## TO: EL PASO COUNTY

May 16, 2017

Re: Colorado Military Academy, PPR-17-012, Review 2 Response

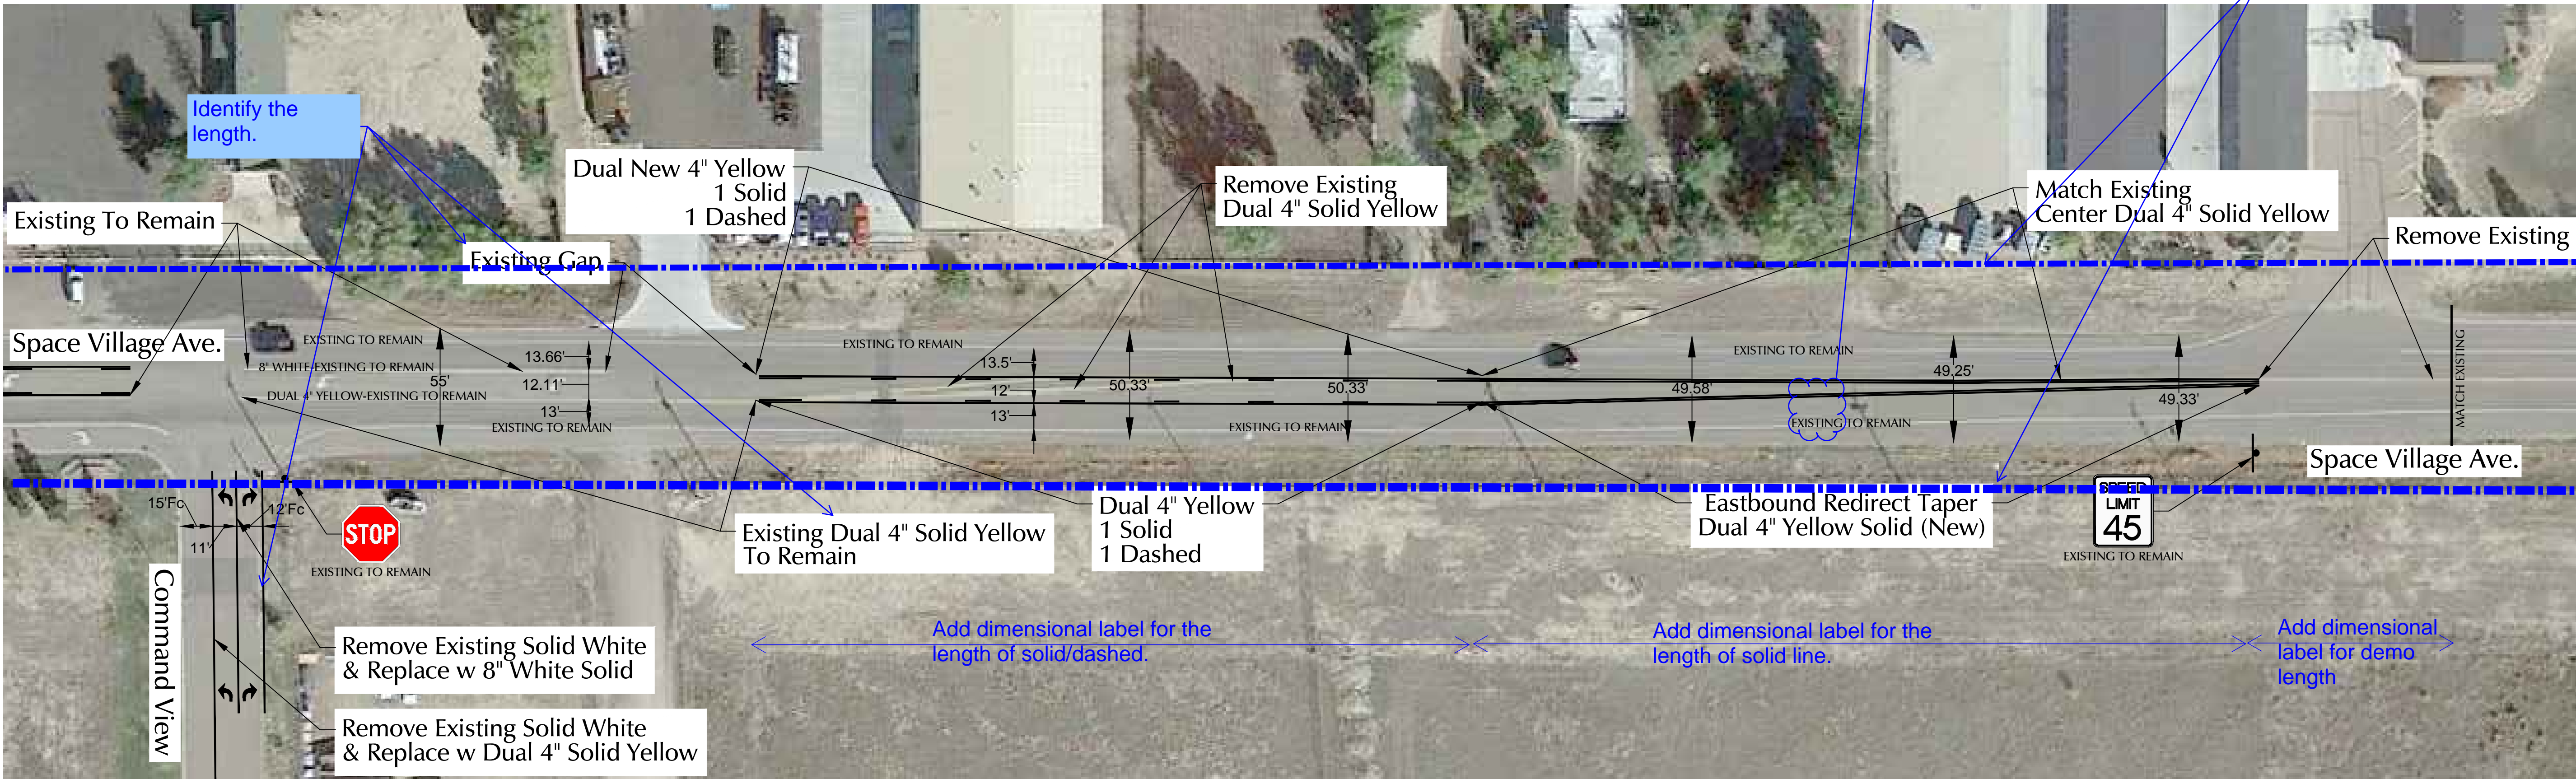
1. See PDF comments on the signage and striping plan.
  - a. *Response: Each comment has been addressed on the Final Signage and Striping Plan as requested.*
2. Engineering comment to the Letter of Intent is resolved.
